Application for Outline Consent

DECISION NOTICE

Application Ref: WA/68/20/OUT

Land west of Tye Lane
Walberton

CONCEPT MASTERPLAN

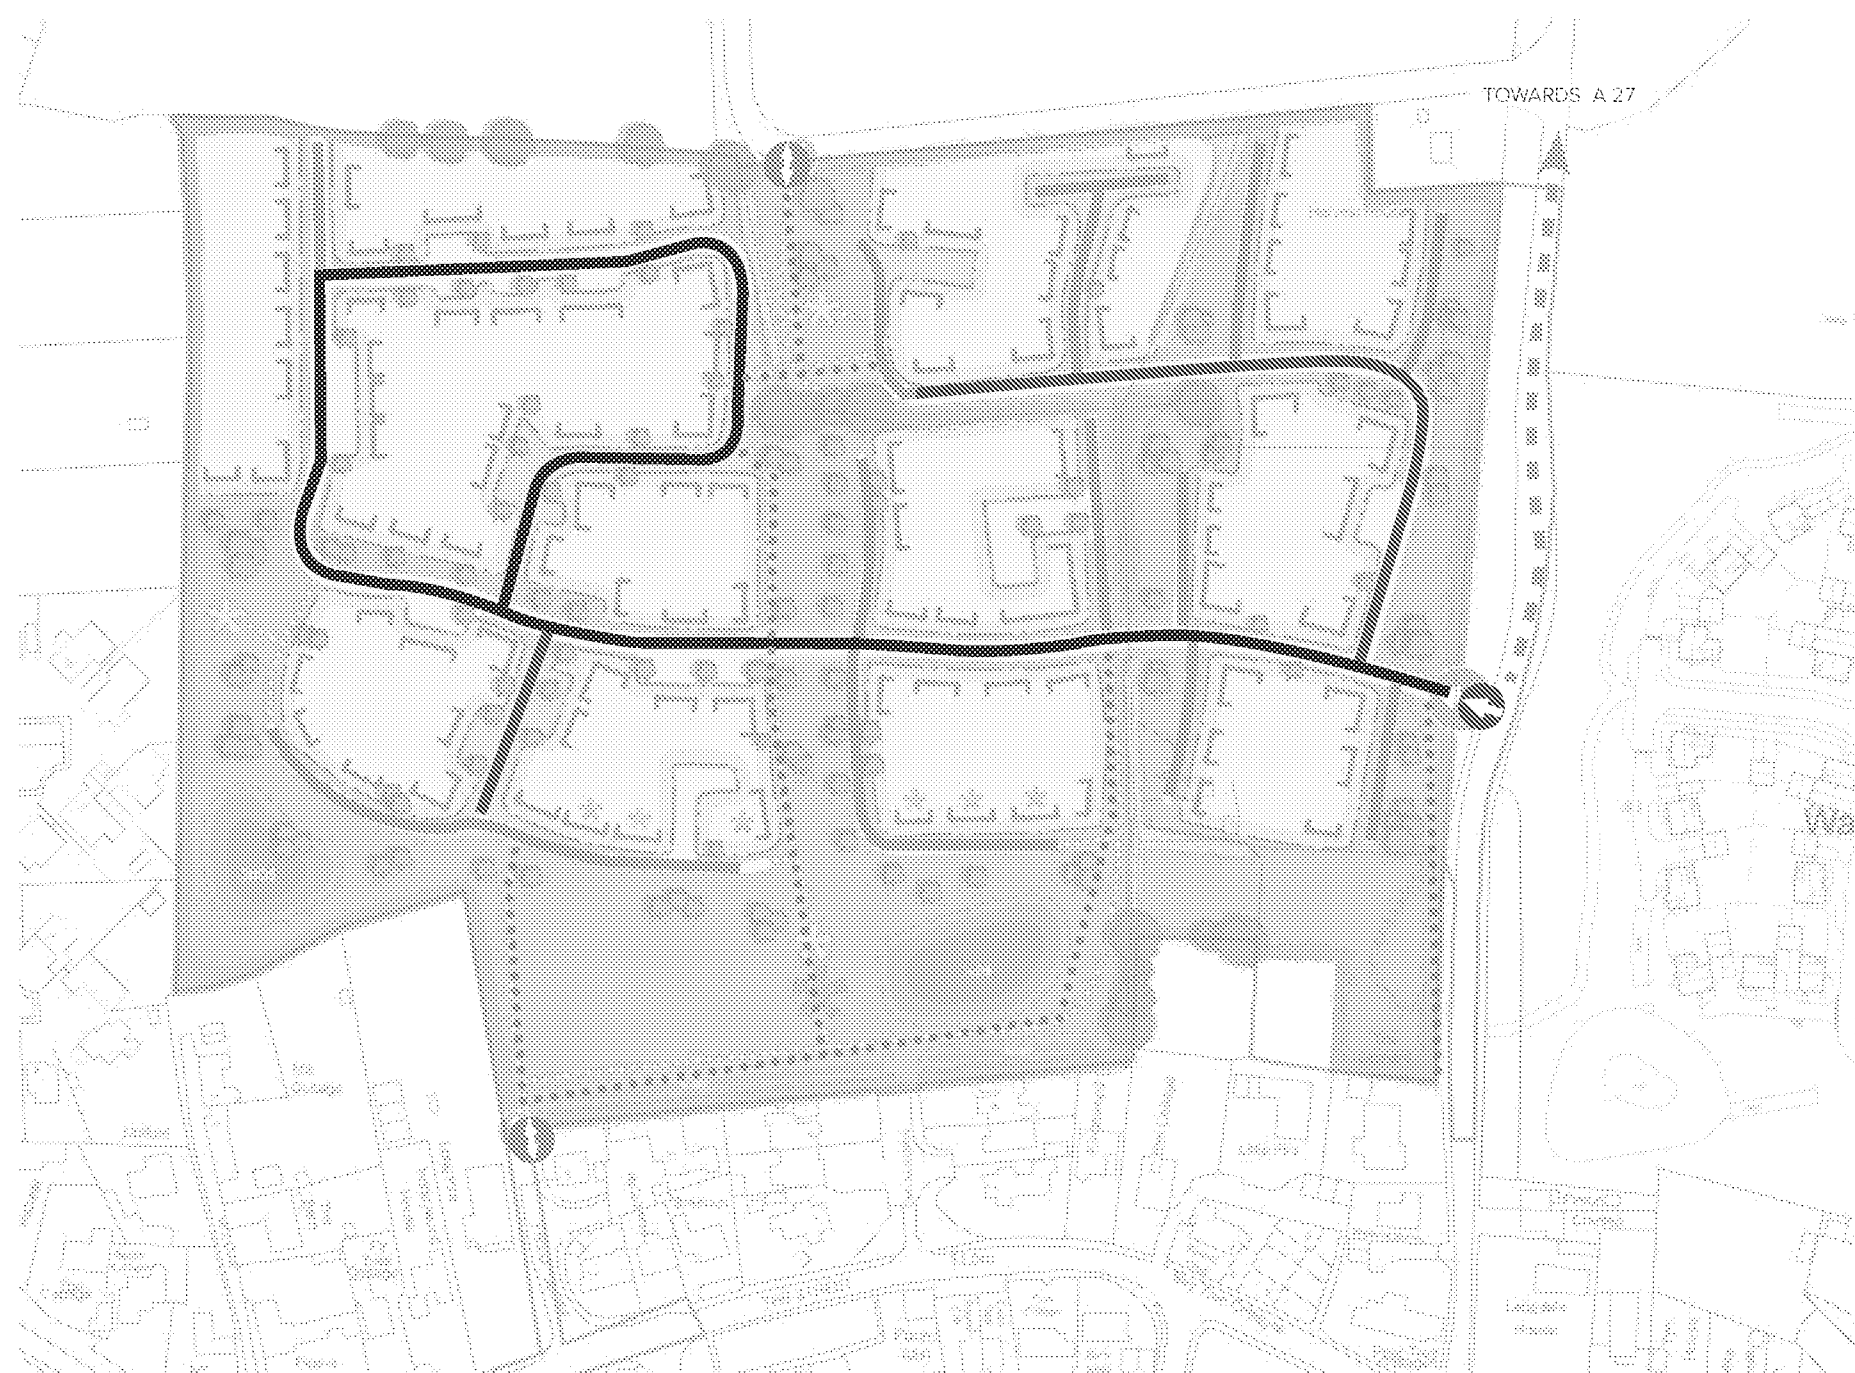
- 4 There appears to be a lack of permeability and opportunities for movement around the individual clusters of housing on the Concept Masterplan and for the provision of Green Infrastructure, especially around the north western corner of the site. Consequently, the LPA is not satisfied that 155 dwellings could be accommodated on this site. The quantum of development on this site would have a detrimental impact upon the character of the site and the surrounding area, contrary to Policy D DM1 of the Arun Local Plan, Policy HP13 of the Walberton Neighbourhood Plan and the National Planning Policy Framework.

- 5 Insufficient surface water drainage details have been submitted to fully determine the viability of the proposed surface water drainage scheme in the Concept Masterplan. Further groundwater monitoring over a full winter period is required. Even if infiltration is ruled out groundwater monitoring is required to inform design of attenuation features including flotation resistance measures. The adverse impact arising from the failure to achieve high quality design by incorporating surface water drainage in the Concept Masterplan is unacceptable and it is contrary to Policy W DM3 of the Local Plan and Policy VE7 of the Walberton Neighbourhood Plan and the National Planning Policy Framework.

MOVEMENT STRATEGY PLAN

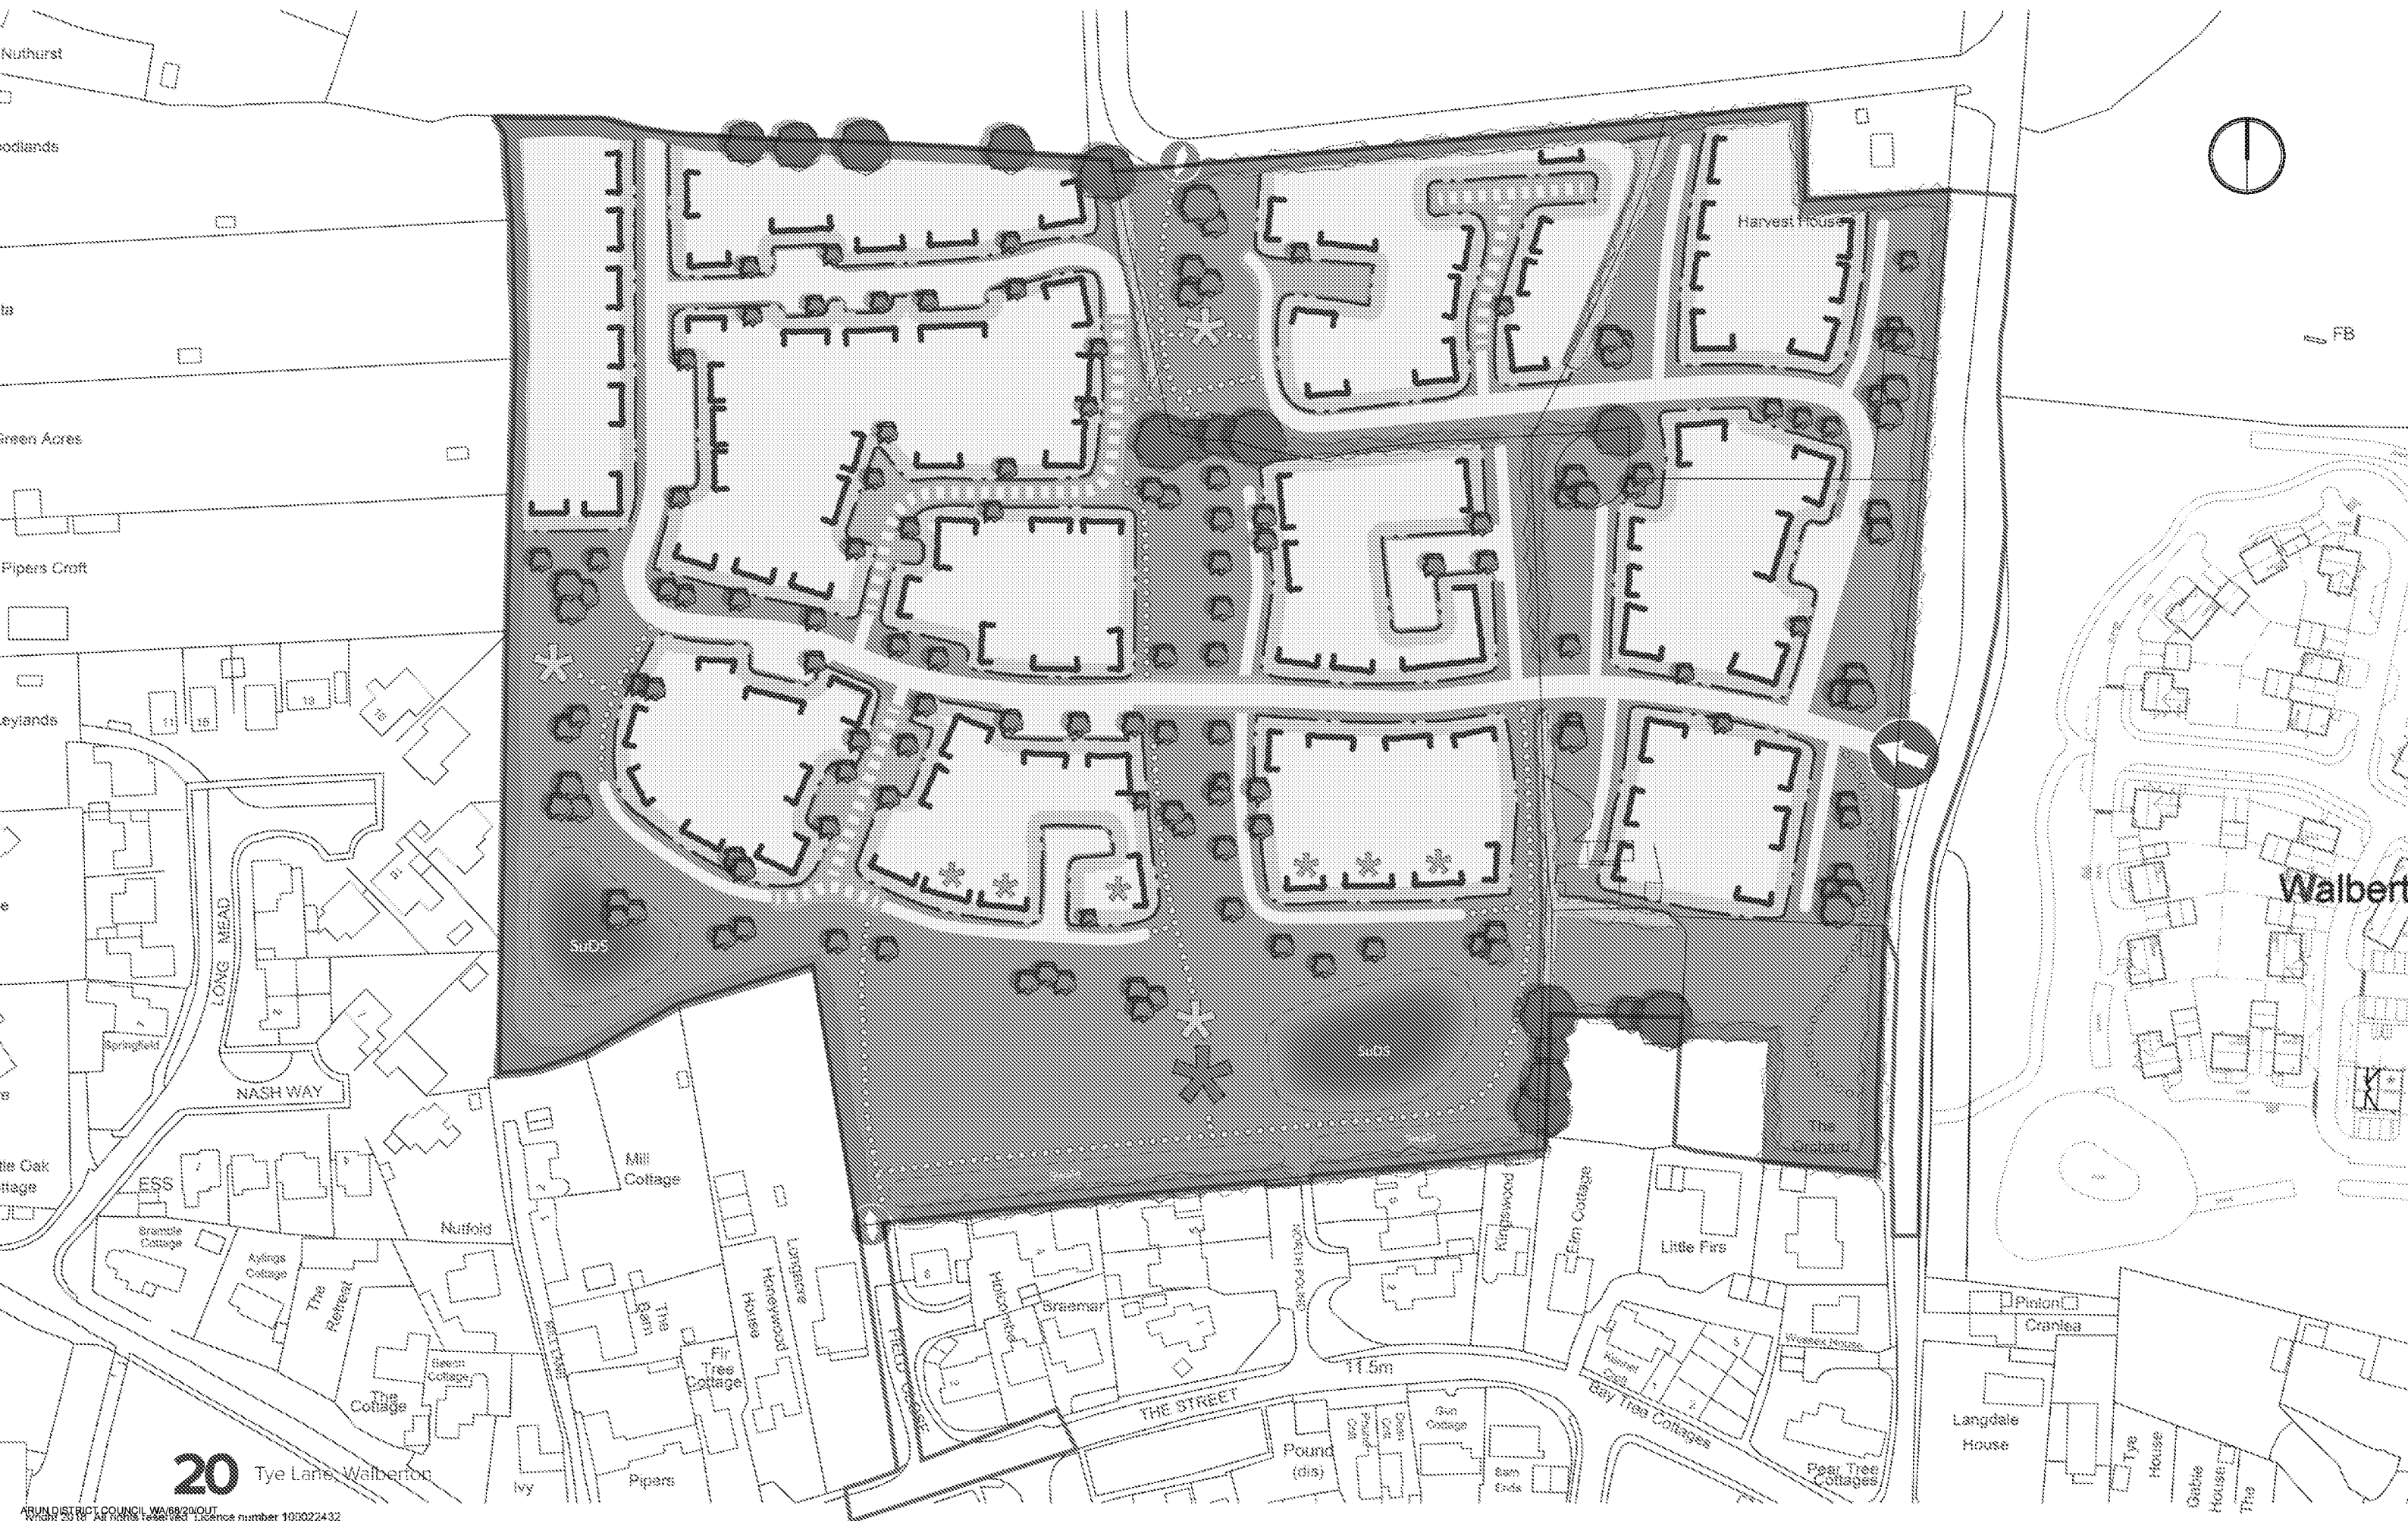
- 3 Insufficient information has been submitted to demonstrate that the proposed development would provide a high quality development with a sense of place and permeable layout including an emergency vehicle' access and a cycleway / footway link southwards to The Street via North Pound, to make the site more accessible from the village centre contrary to Policy D DM1, Policy T DM1 of the Arun Local Plan, Policy HP13 and Policy GA2 of the Walberton Neighbourhood Plan and the National Planning Policy Framework.
